Re: AW/246/19/PL - Erection of 1 No. 2 Storey End of Terrace House at land adjacent to 34 Wakefield Way, Bognor Regis PO21 3RS

OBJECTION TO THE AFOREMENTIONED APPLICATION

I refer specifically to IBA Drawings IBA/520/01, 02 & 03.

Site Plan

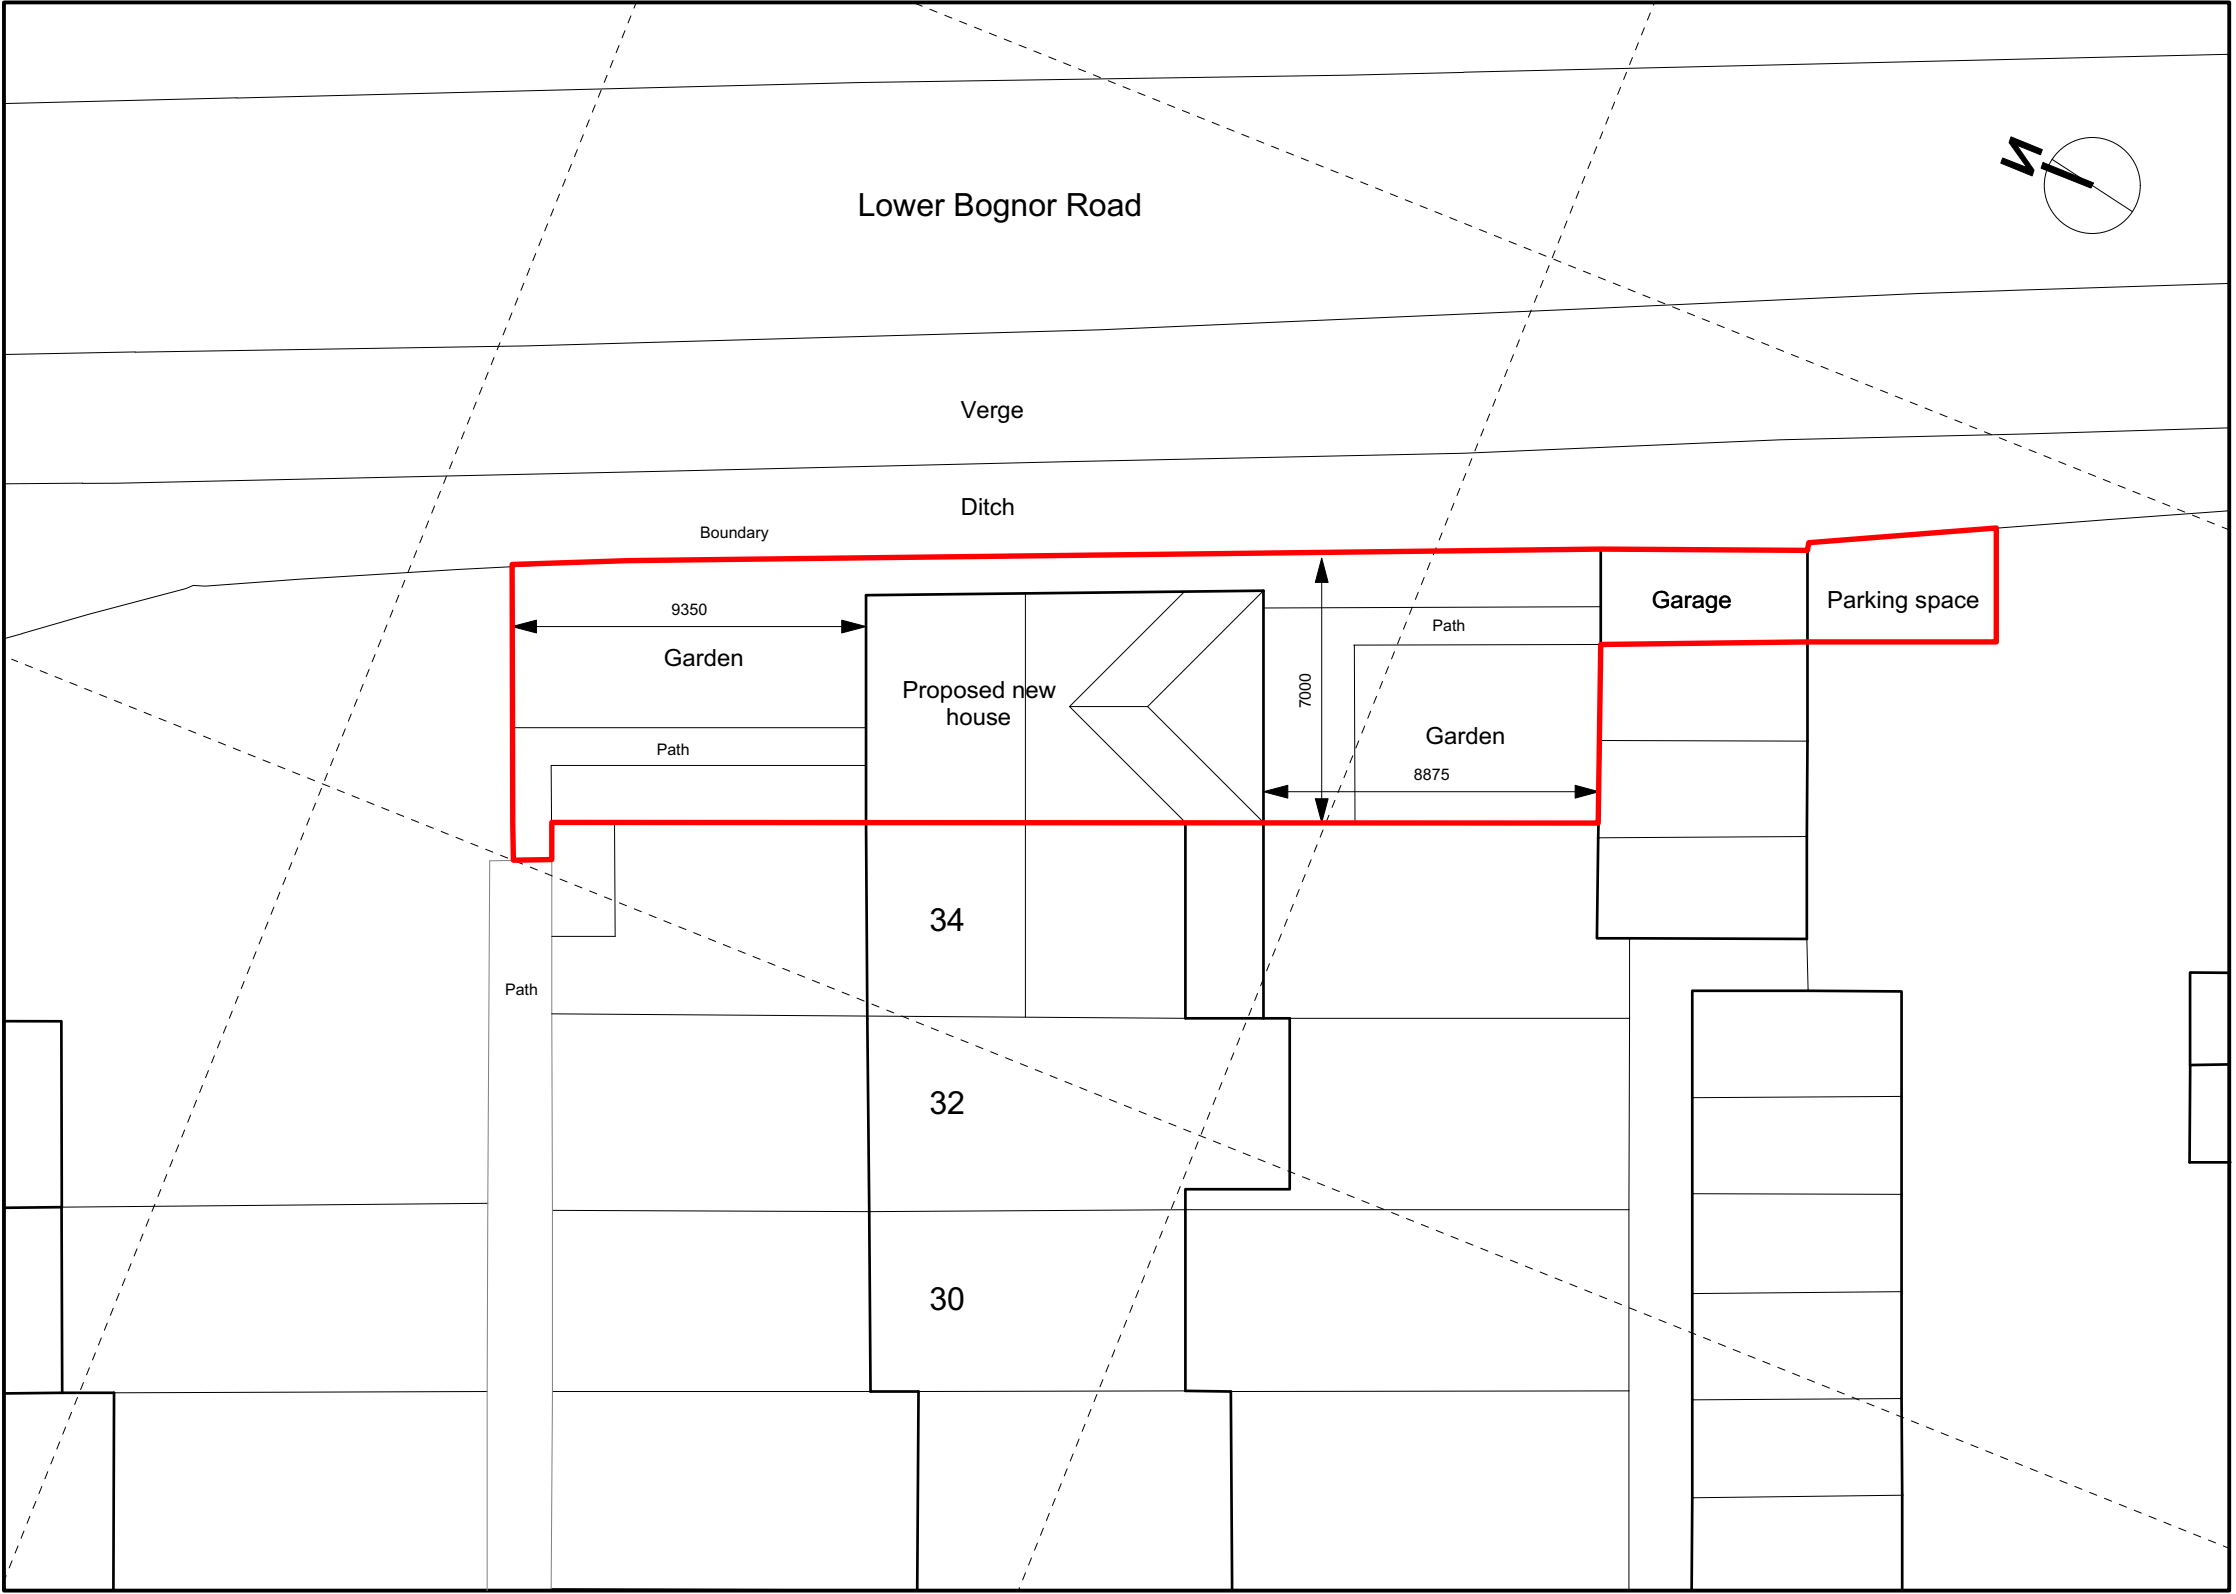
In paragraph 2 of the Design and Access Statement on Page 5 of the self-named document, I quote *"Parking is provided on site, with one garage space and one parking space in front of the garage"*

According to the WSCC Consultation on the planning application the WSCC PDC **requires** a minimum of three parking spaces to be provided for this size dwelling in this location.

According to the D&A Statement the proposal by the Applicant would only give 2.

It is our belief that neither of these two proposed spaces constitute a parking provision for the dwelling.

The first of which is a garage situated at the far end of the L/H side of the garage block. This garage is apportioned to No.34 (the existing dwelling) therefore no "additional" space has been created, it has simply been re-assigned from an existing dwelling to the proposed. This conclusion has also been noted within the WSCC Consultation.

There is also a further point to the proposed use of a garage as a parking space within this application. As per the WSCC Consultation, the garage in question is only 2.5m wide and 5.5m long. This is barely big enough for a standard size family vehicle. However, the Design and Access Statement submitted makes note that the garage will also be the "Bin Store" for three wheeled refuse bins along with space for two bicycles. I do not see how a car, three wheelie bins and two bicycles will fit into this garage. The floor space is simply not enough.

Secondly the area of hard standing in front of the garage cannot be assigned to any one property as it does not fall within the ownership boundaries of the existing dwelling.

Therefore, no portion of the forecourt area can be apportioned to any one property as its title belongs to all persons entitled under the same Schedule accompanying their deeds.

In short, no provision of any spaces has been provided for the new dwelling, therefore not meeting the regulatory 3 spaces as set down by the WSCC in their PDC.
